From: Kingston Parish Council [REDACTED]
Sent: 01 July 2015 13:18
To: Ross Leal
Subject: Re: Russet House, Gorse Avenue, Kingston Gorse, Kingston - K/17/15/HH

From: Ross Leal
Sent: Tuesday, June 30, 2015 9:45 AM
To: Kingston Parish Council [REDACTED]
Subject: Russet House, Gorse Avenue, Kingston Gorse, Kingston - K/17/15/HH

I refer to the above application.

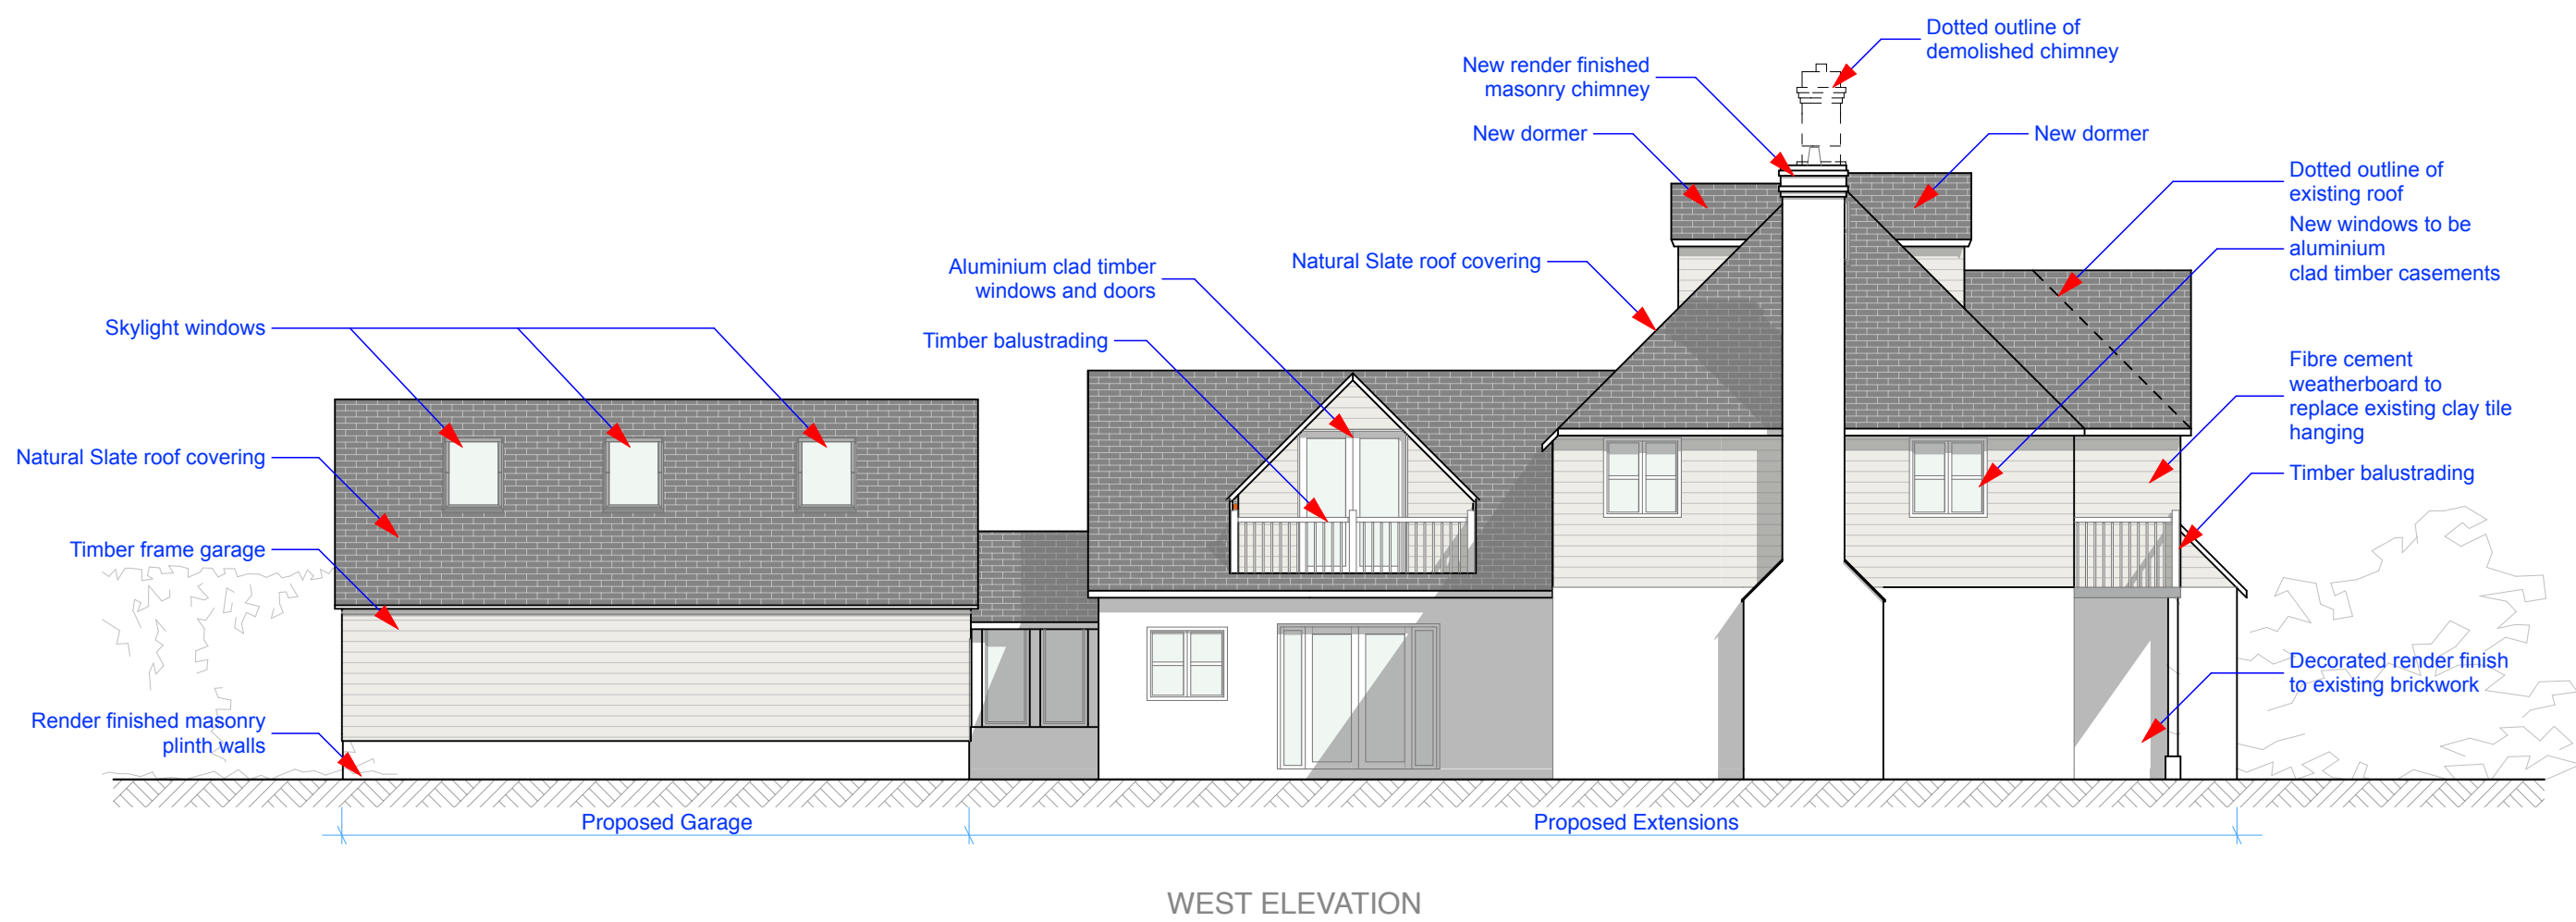
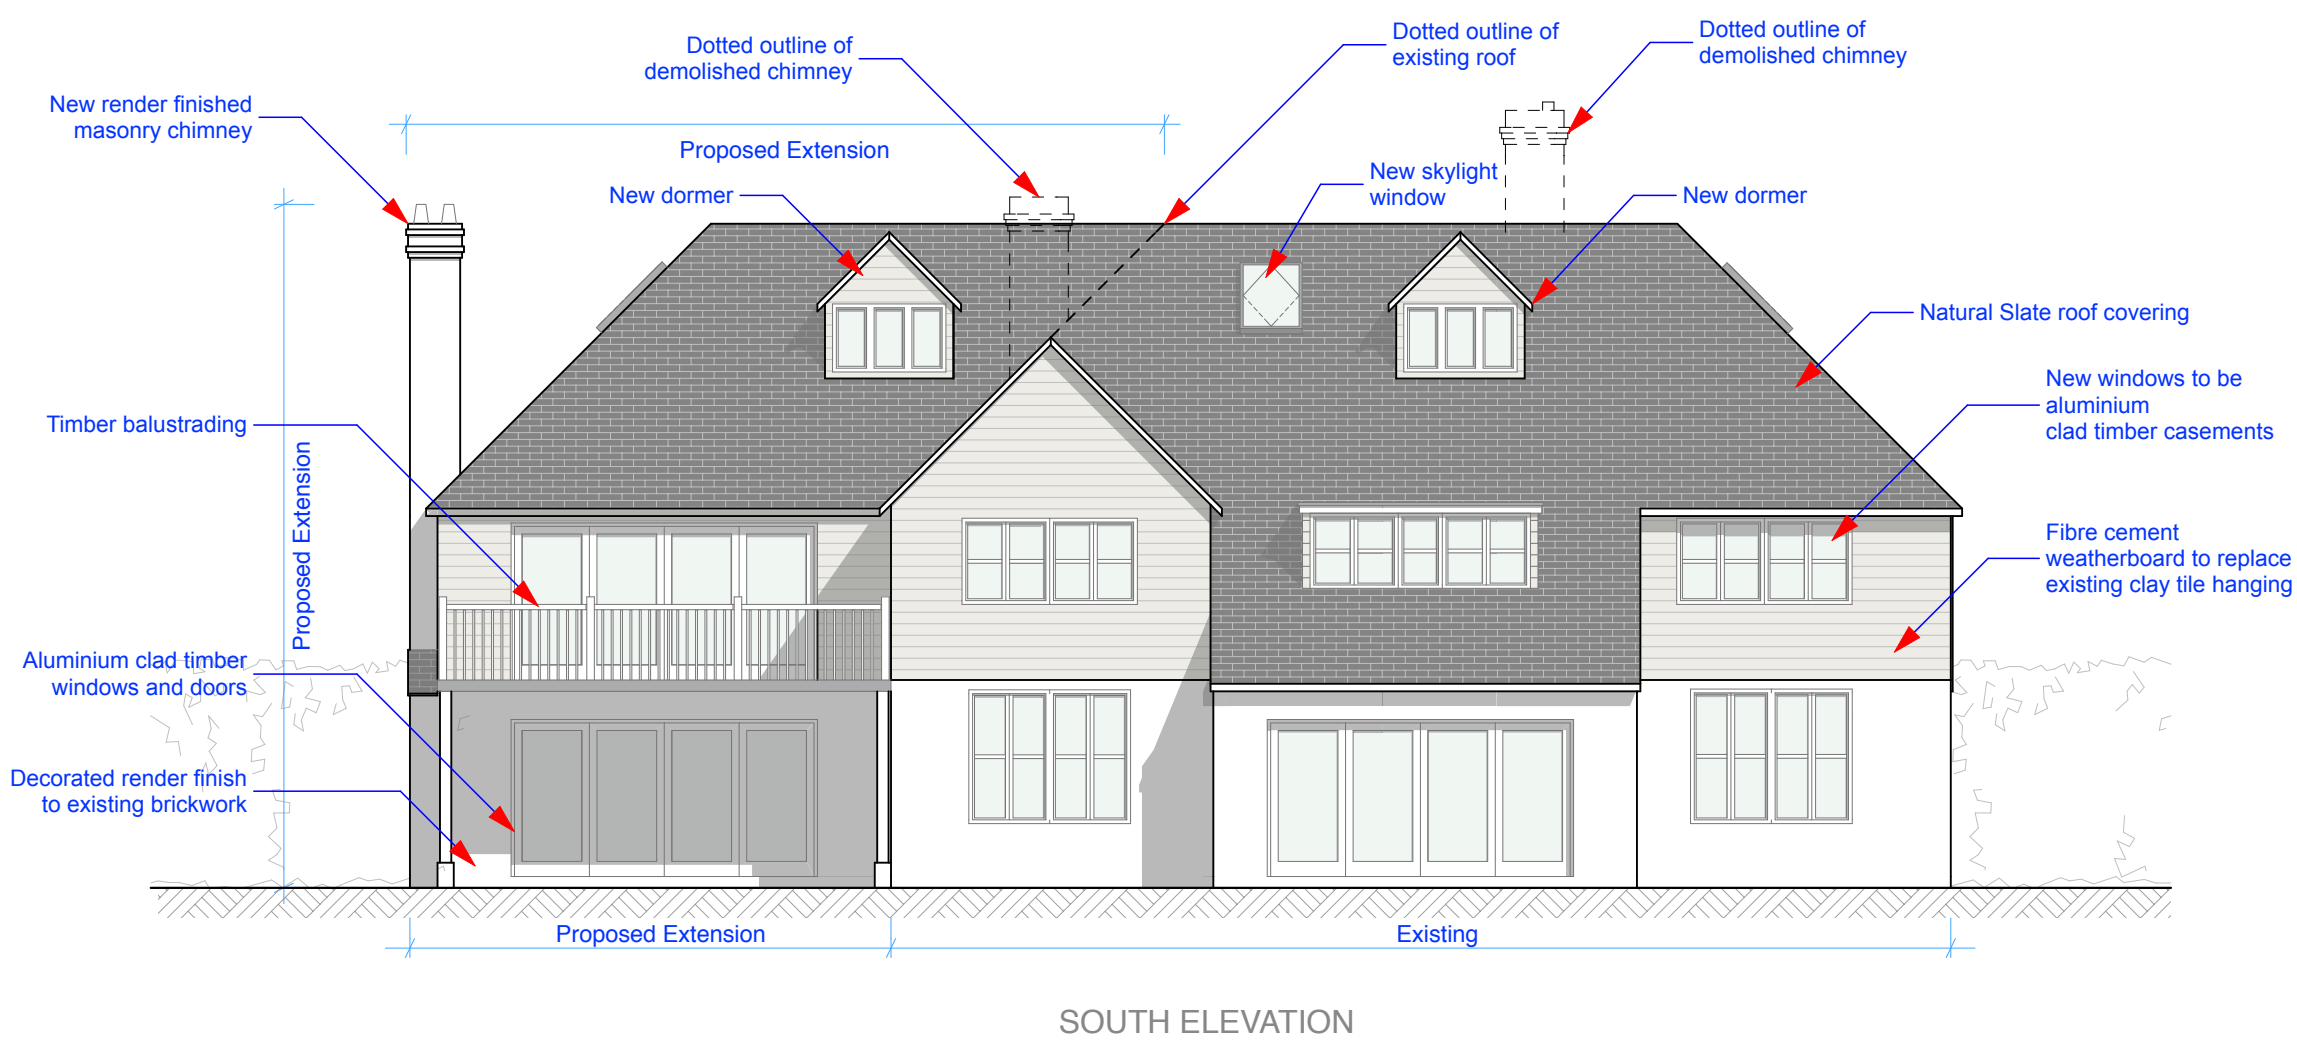
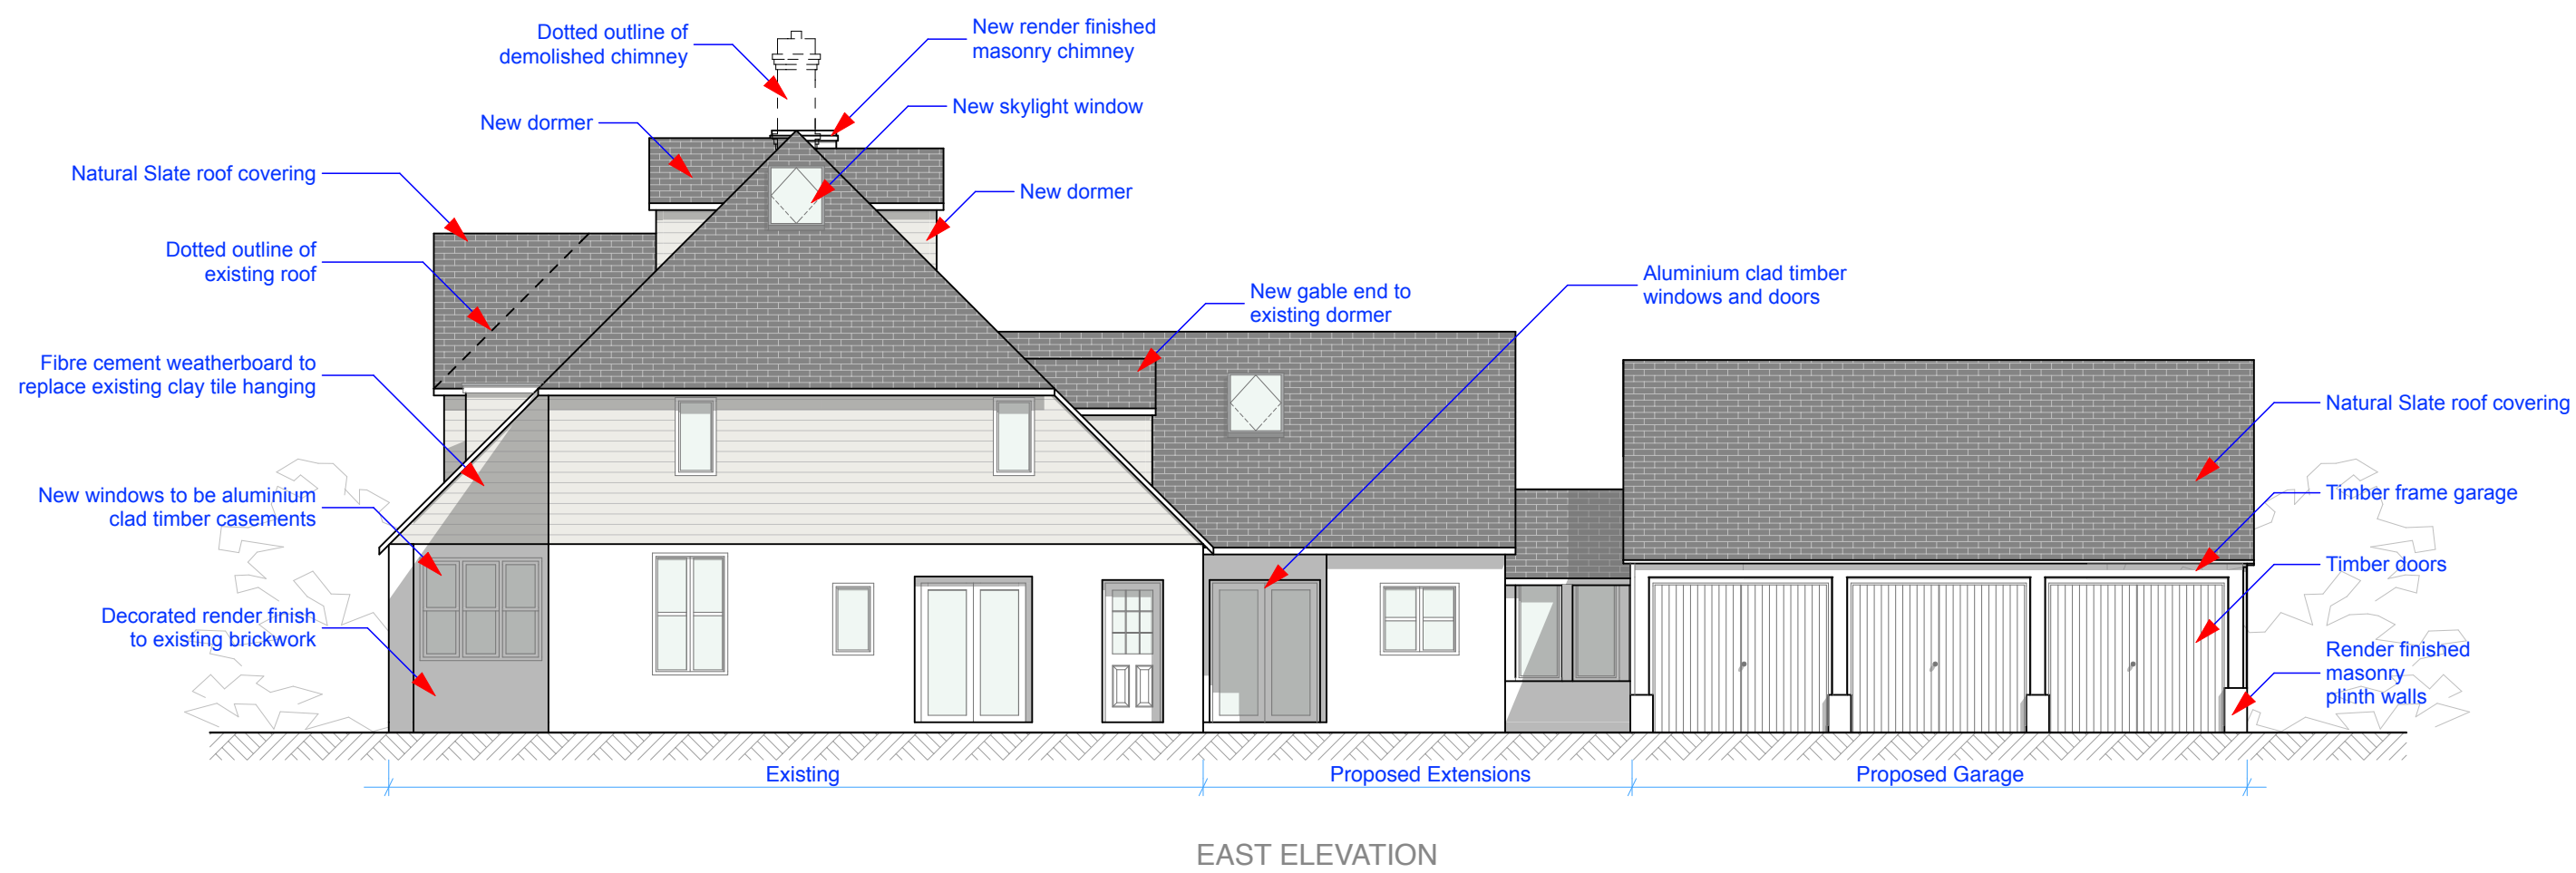
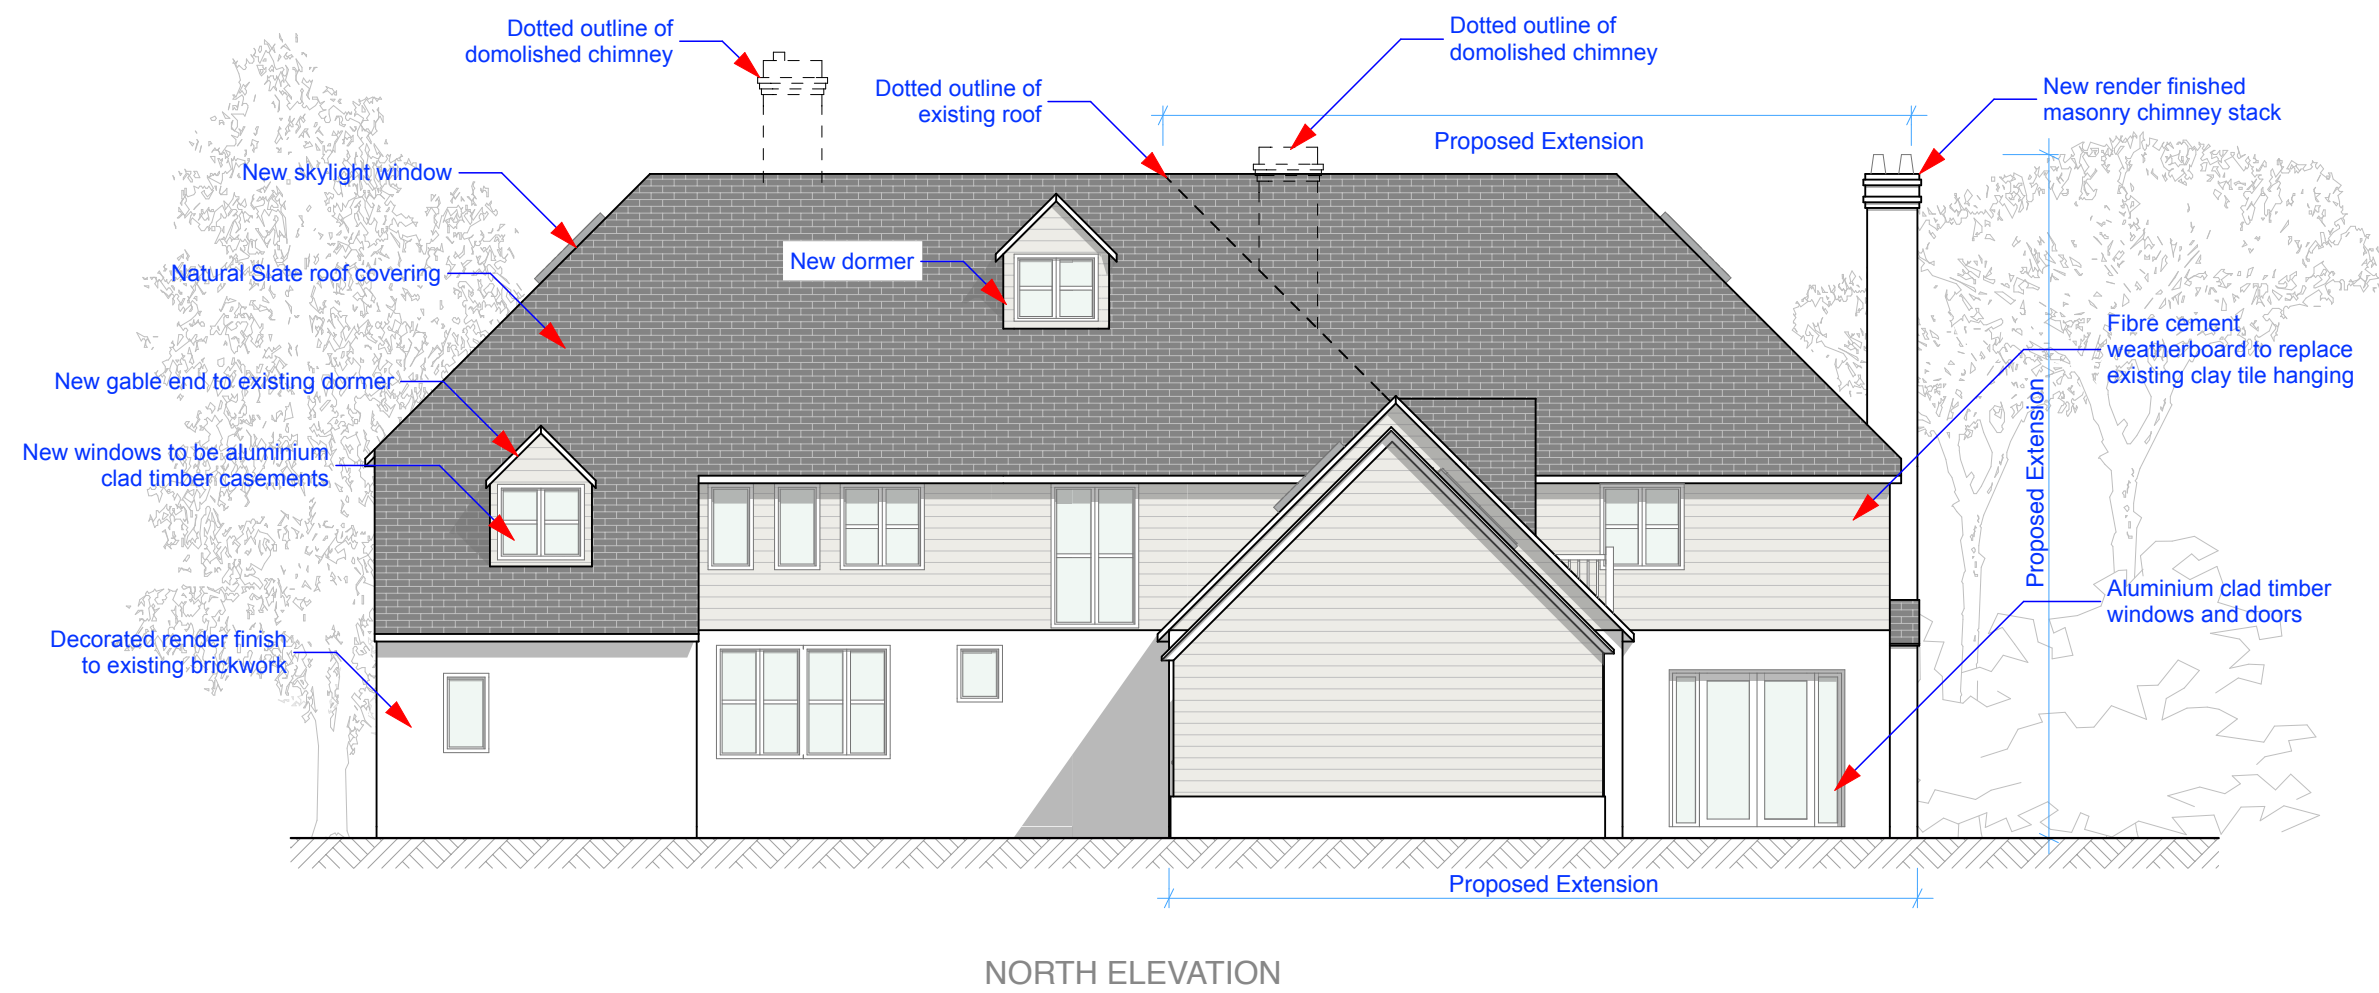
1. Retain existing hedging
2. Privacy screening to balcony.

I have attached a copy of your Council's response to this application, together with a response from the agent/architect which followed. You will see the suggested privacy screening is acceptable and that therefore the PCs concern in this respect has been met. The privacy screening can be secured by condition. Existing hedging is to
